Your Ref: OWPC18940
Our Ref: P/49/18/HH 30-04-2018
Please ask for:
Mr S Davis

2 storey infill extension to front elevation & 1st
floor infill extension to rear elevation.

39 Conway Drive Pagham

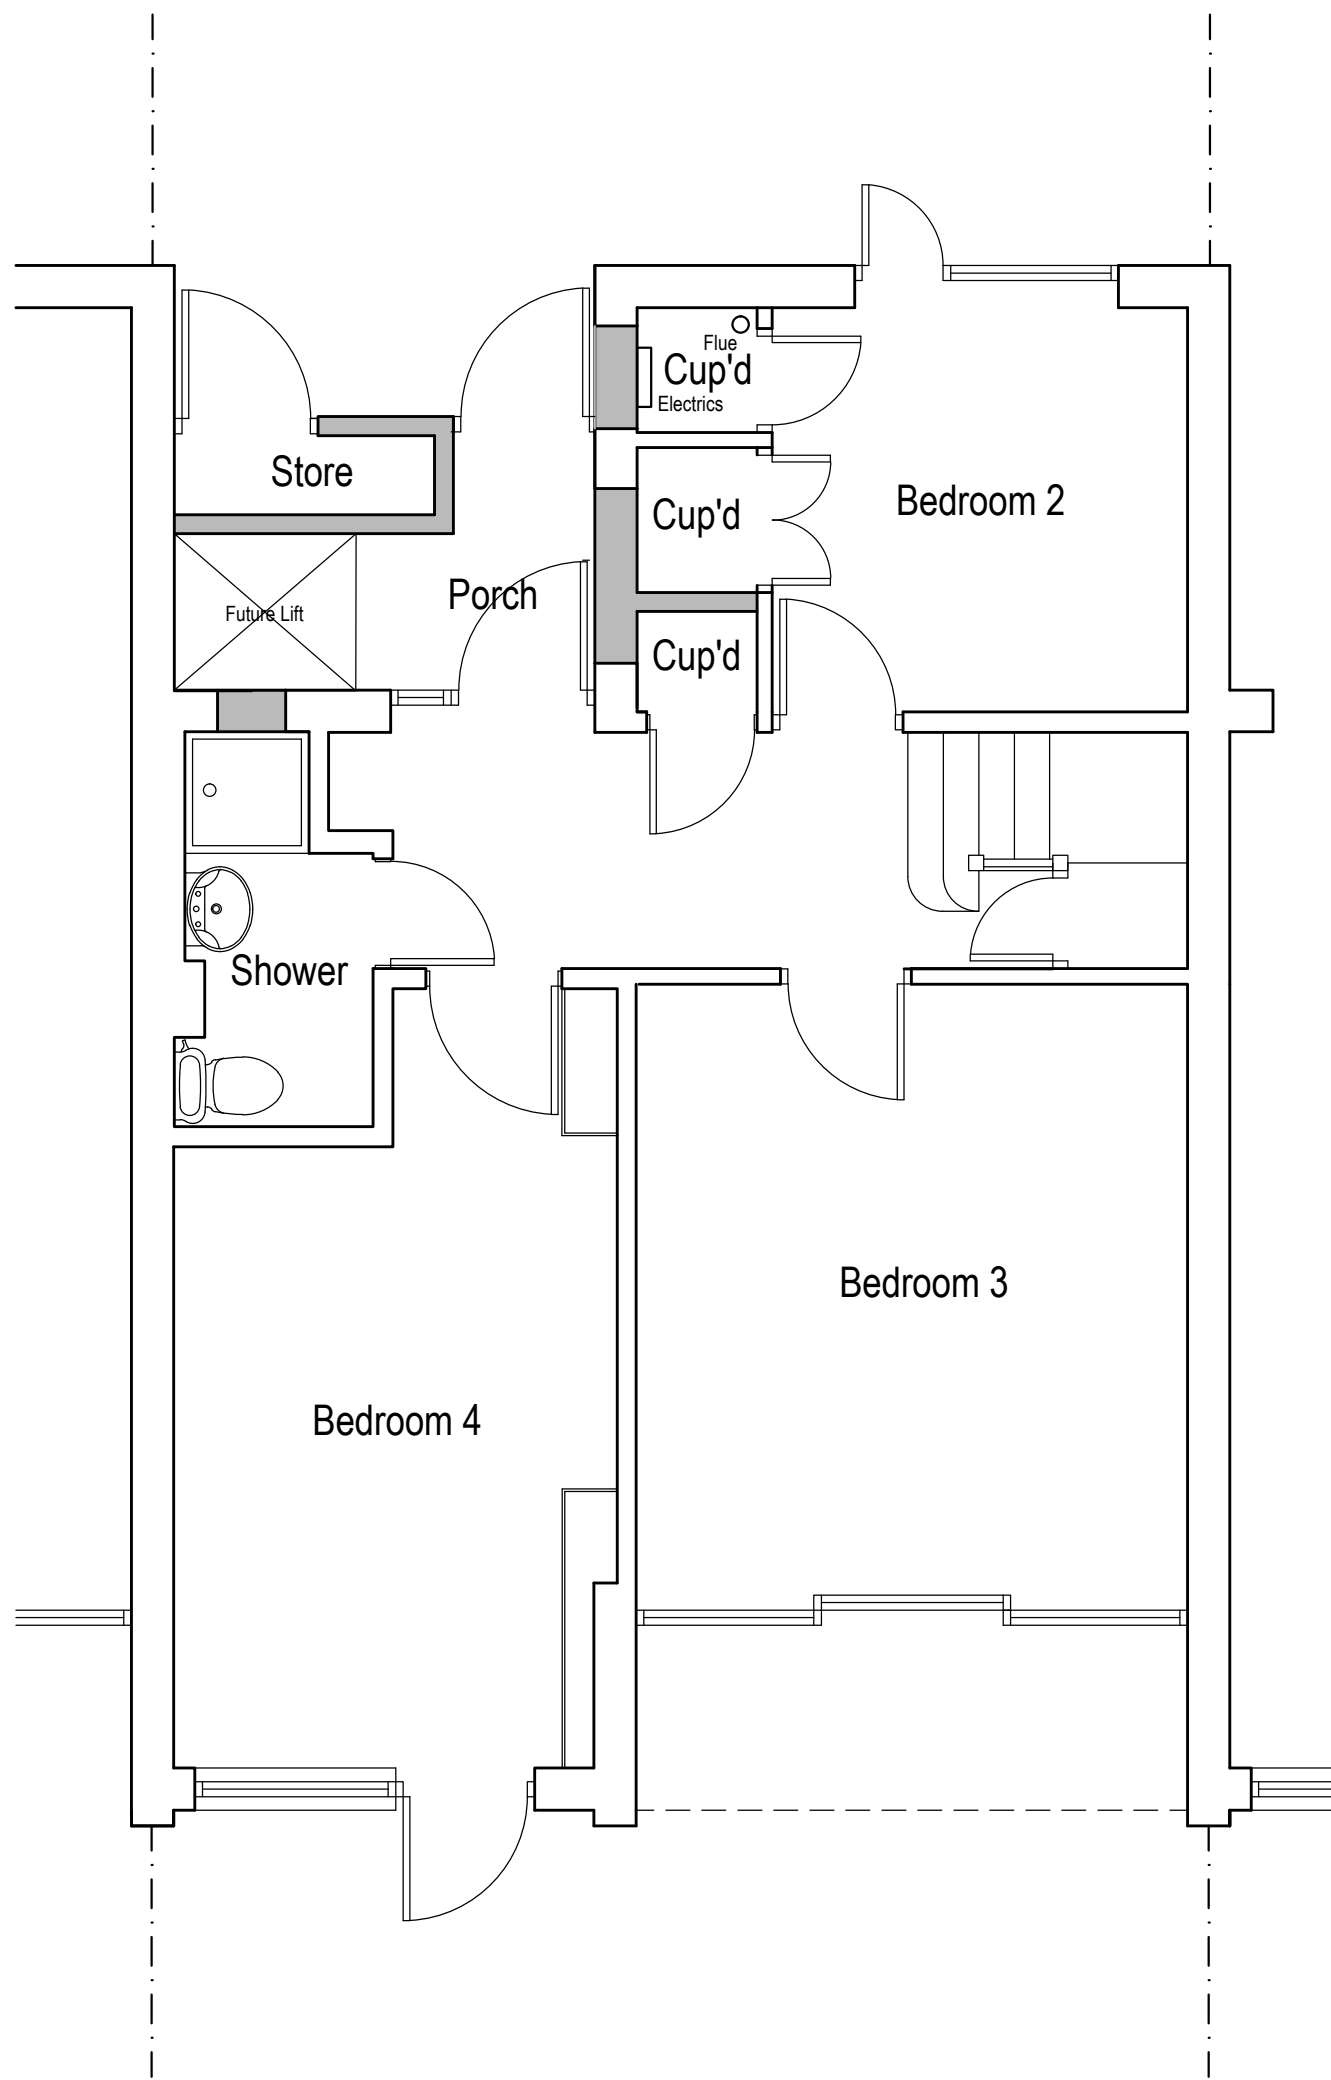
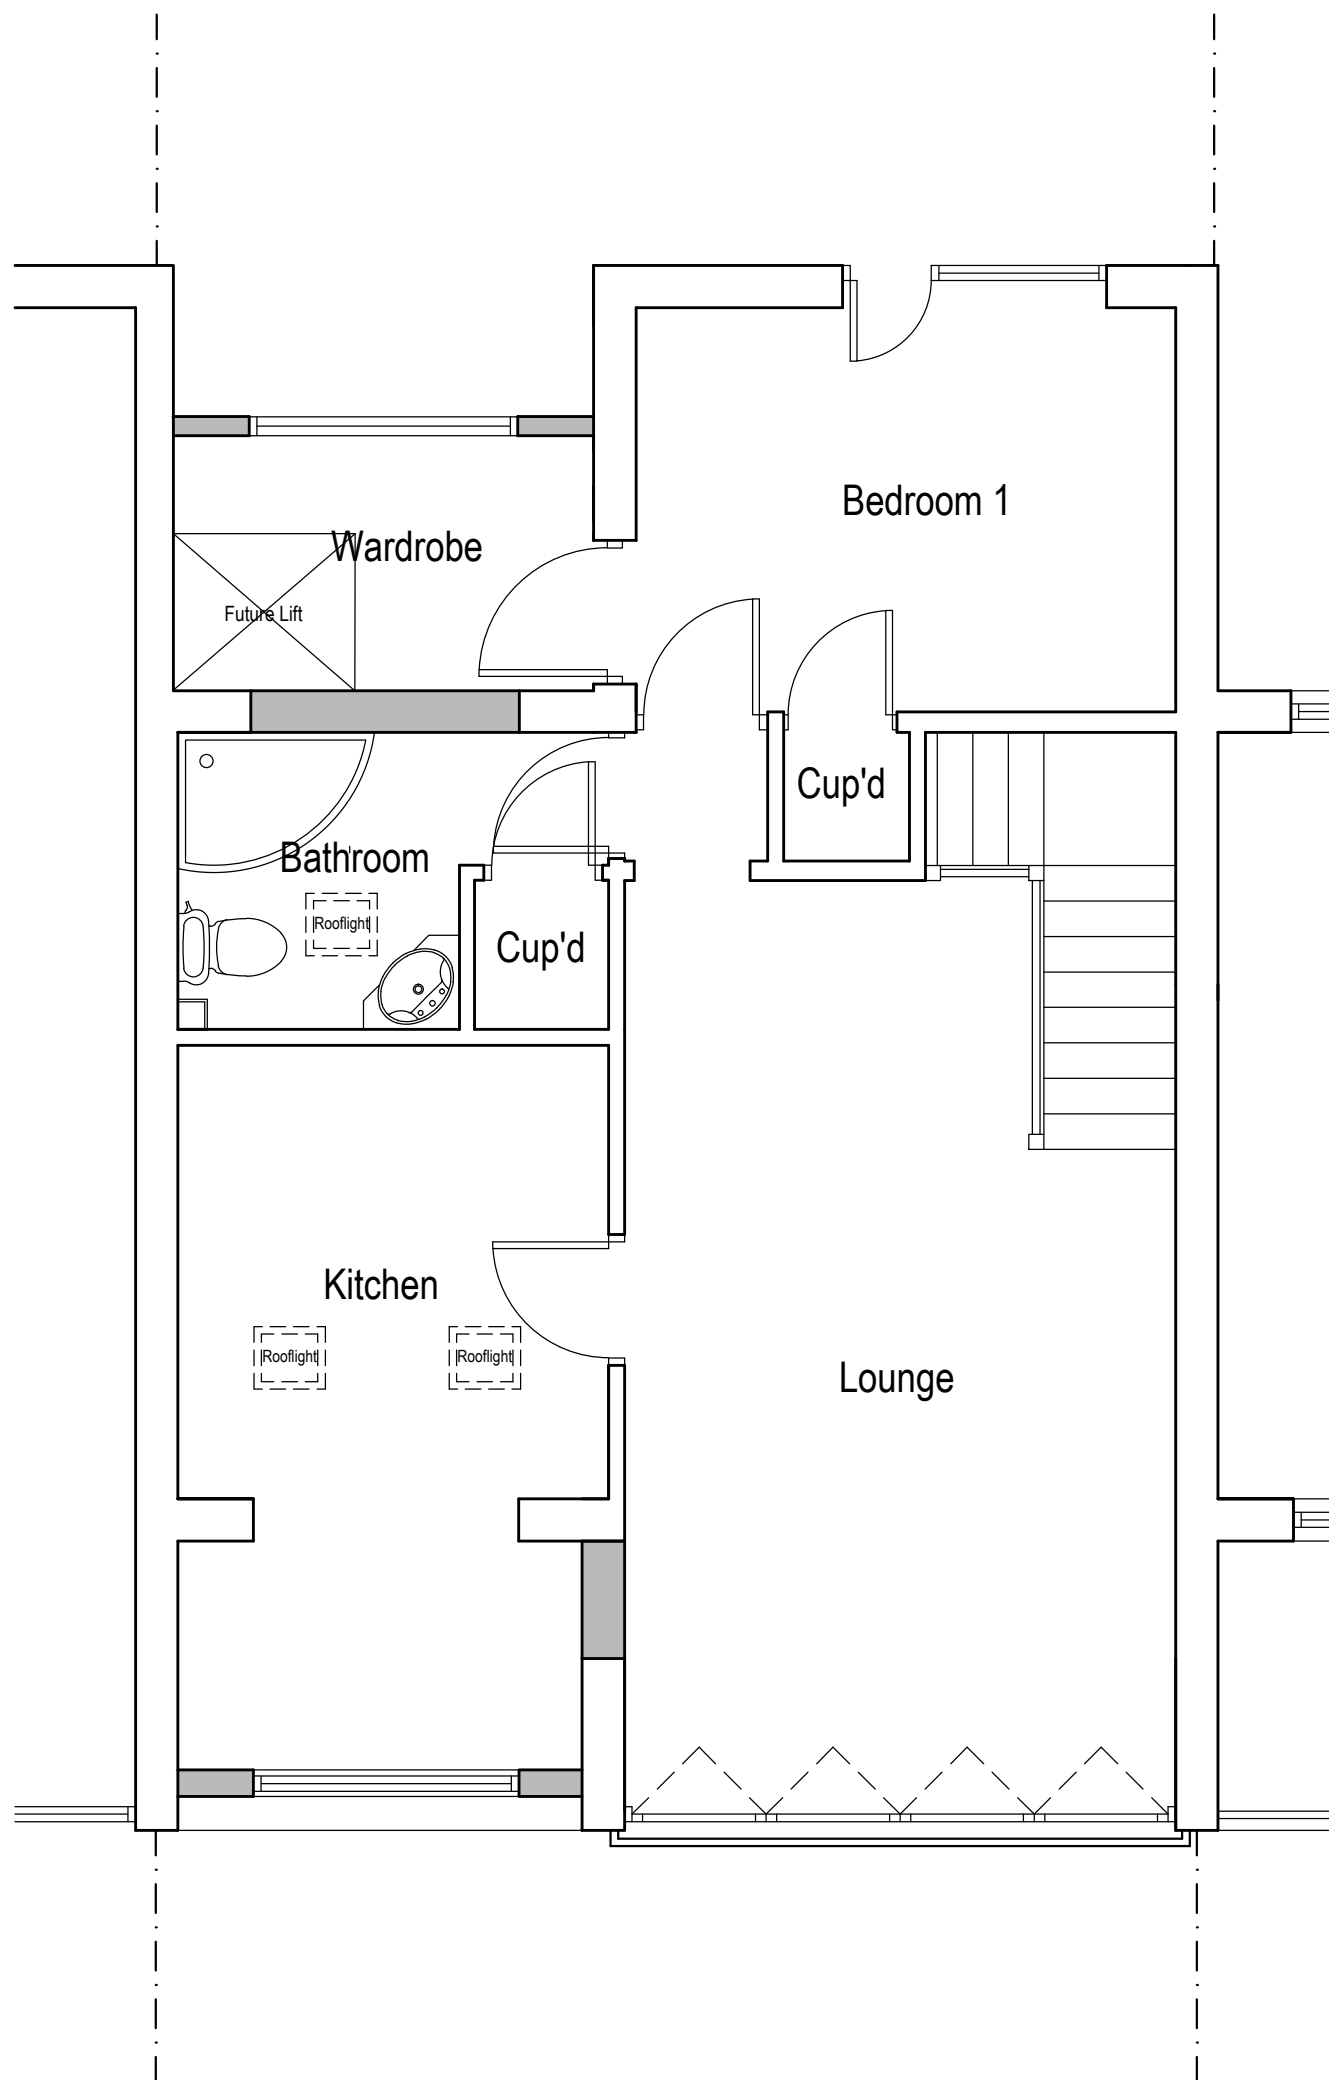
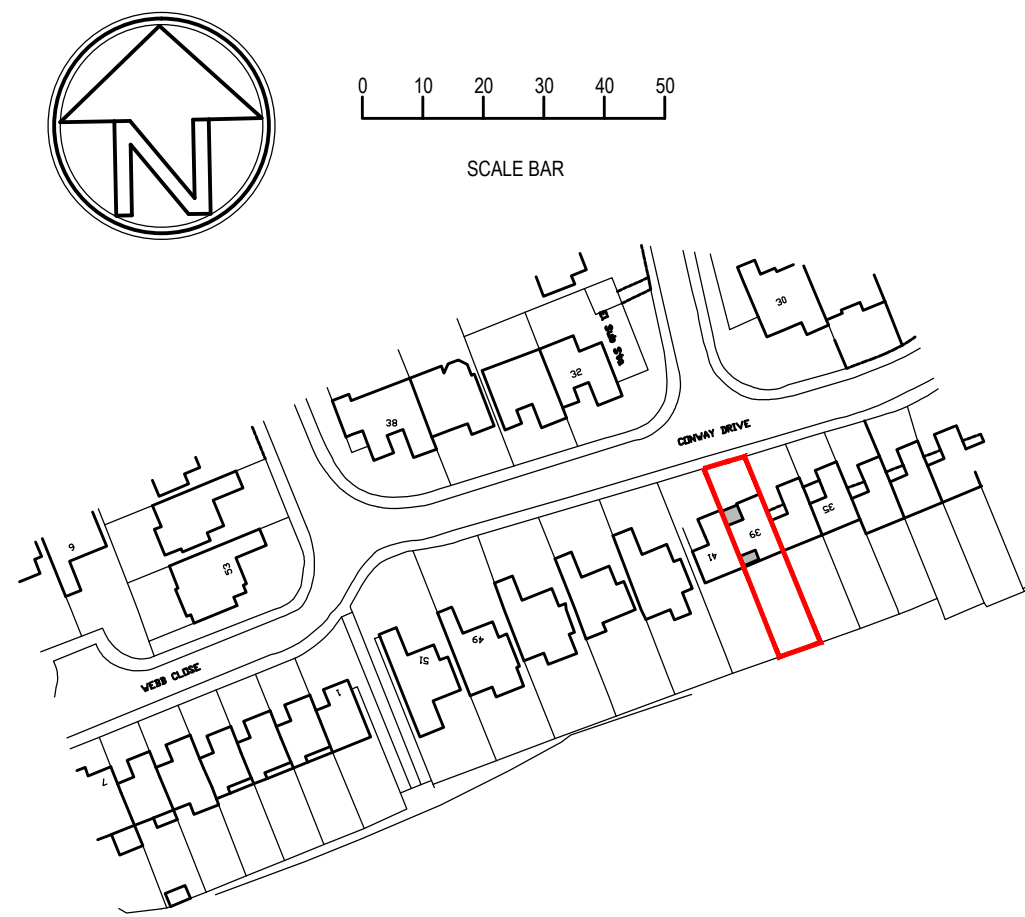
As a new resident to Conway Drive I am supportive of all efforts to improve local properties, so long as any improvements are appropriate and sensitive to the preservation of the visual character of the neighbourhood. I feel that the terraced house appearance indicted by this proposal would have an adverse effect on the unique link detached style of the properties in Conway Drive.
